Application H21-1136-23
Location Land north of 29 Station Road Tydd Gote Wisbech PE13 5QA
Proposal Proposed holiday lodges and yoga building

Name Stuart Greenfield
Address Building Control - South Holland District Council

SITE PLAN 1:500

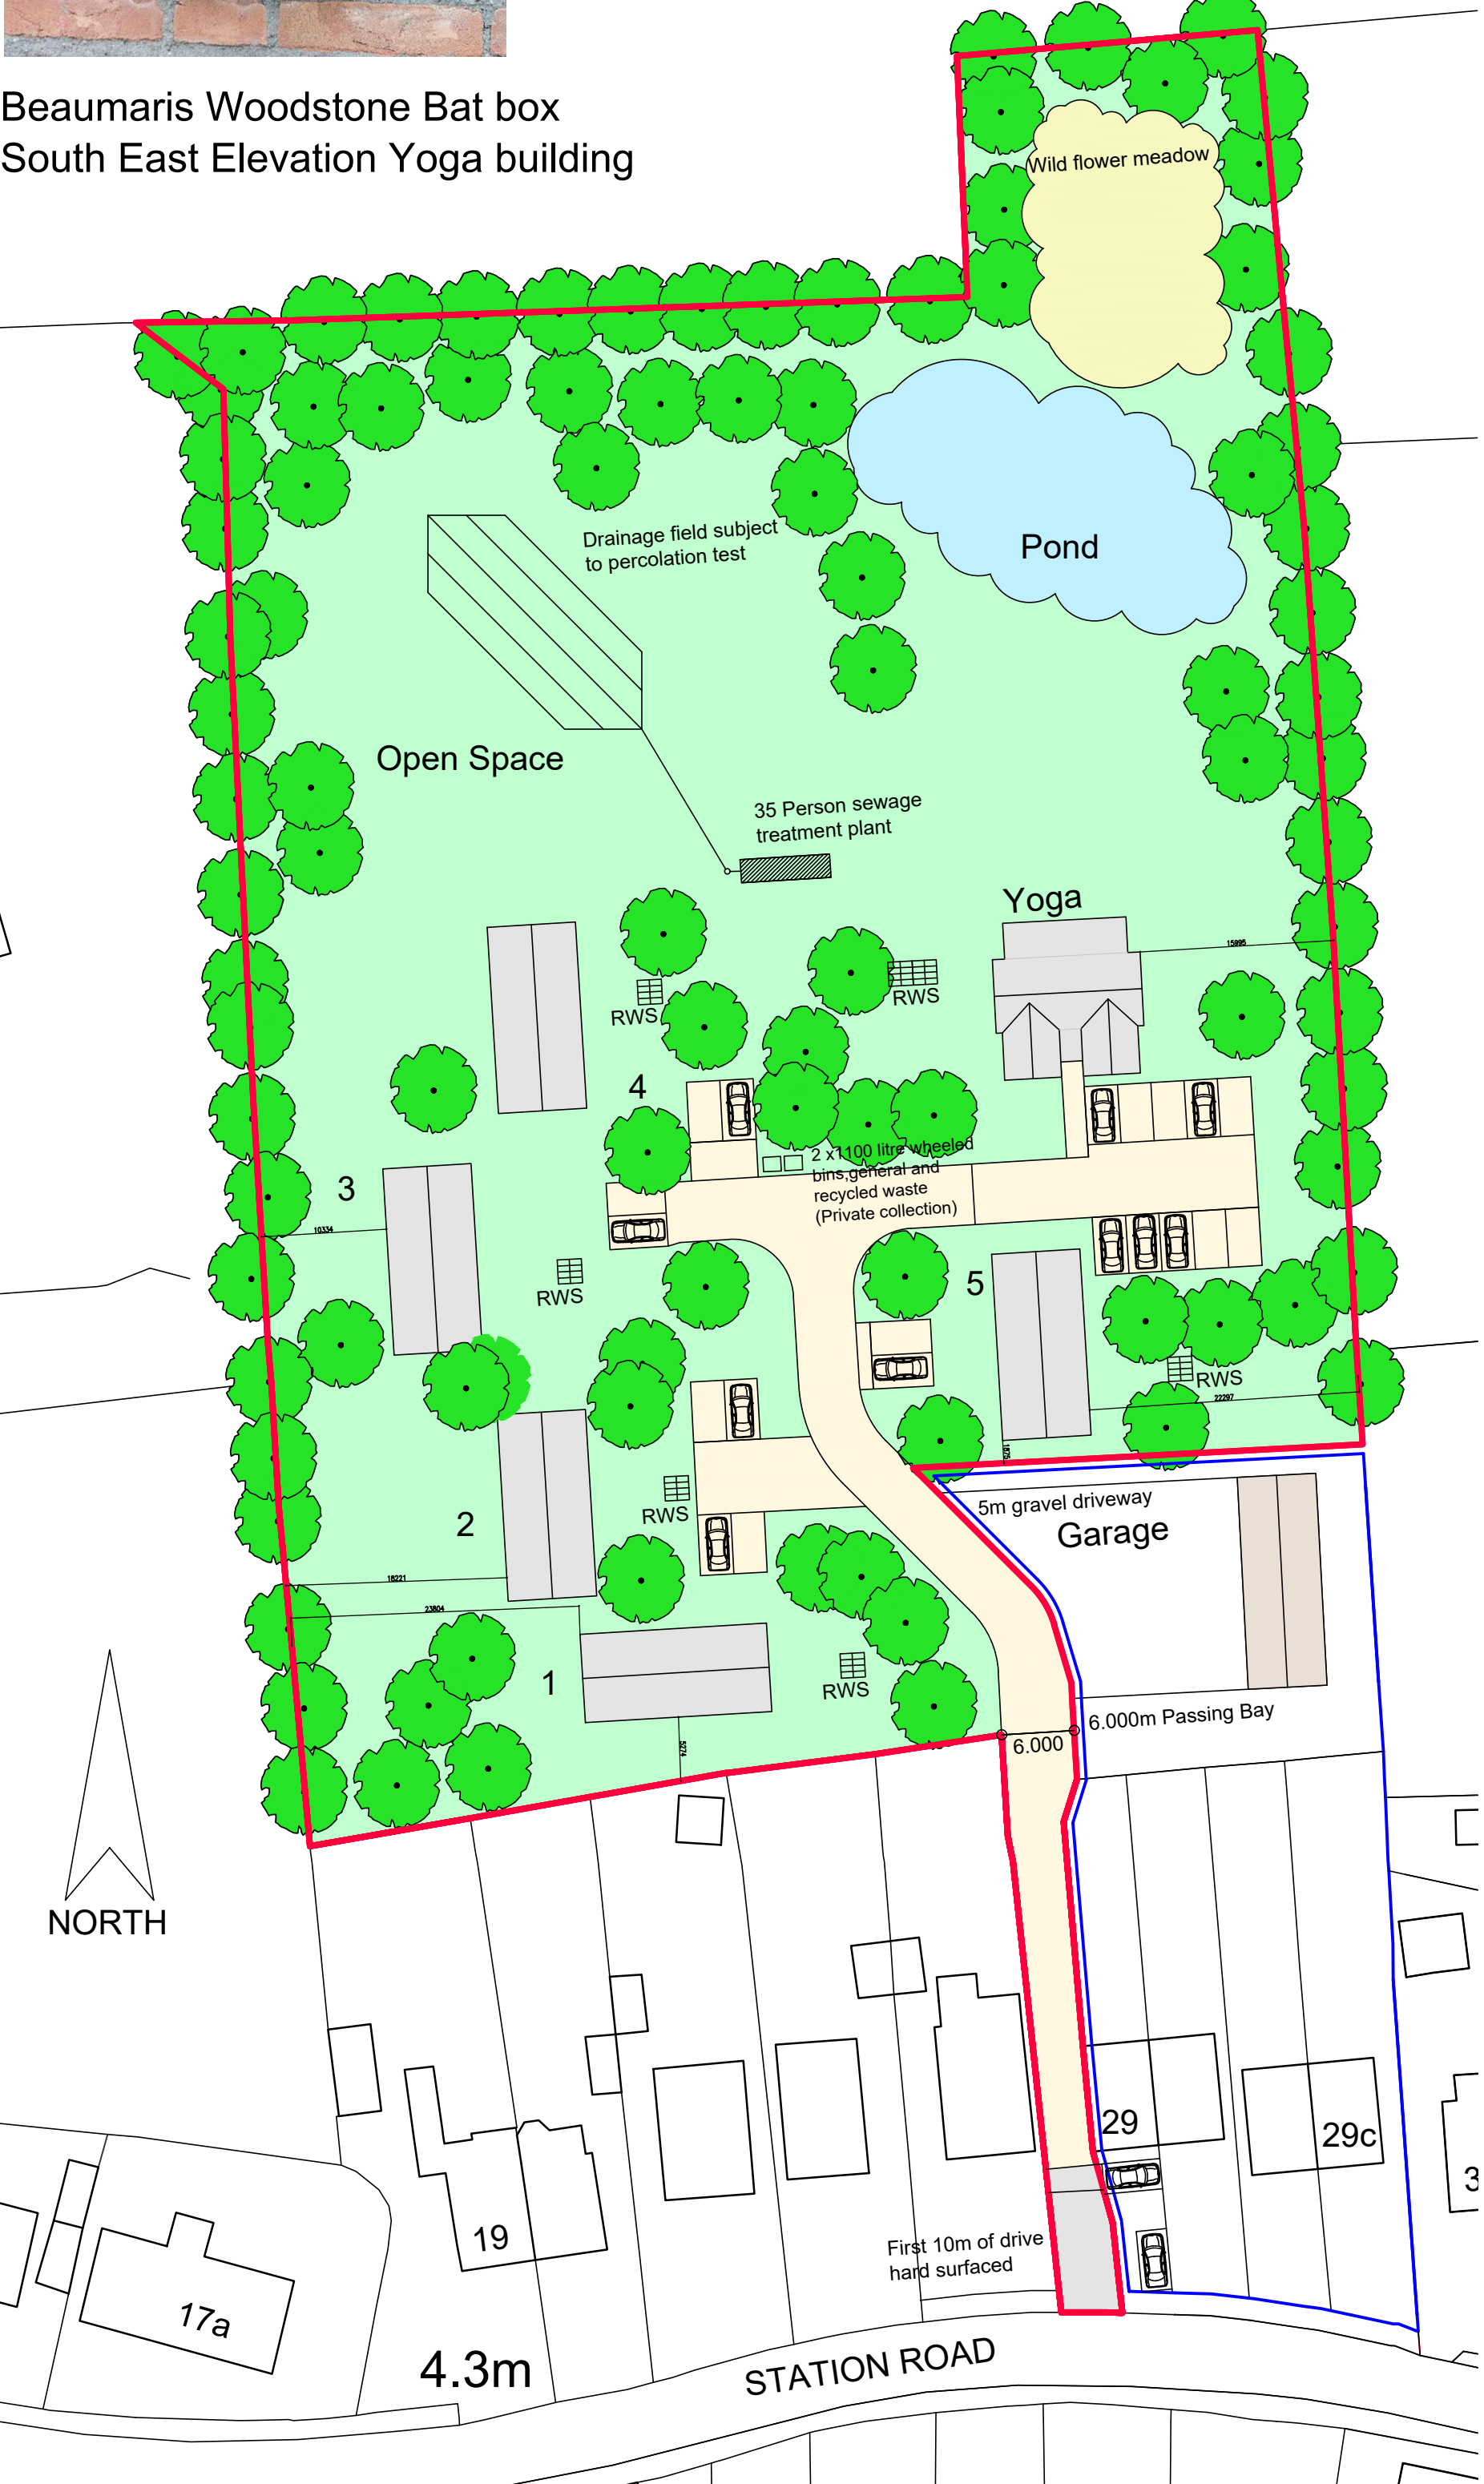
The access road should have provision for supporting an 18 tonne Fire Appliance to within 45m of every point of the footprint of every building and have a minimum width of 3.7m.
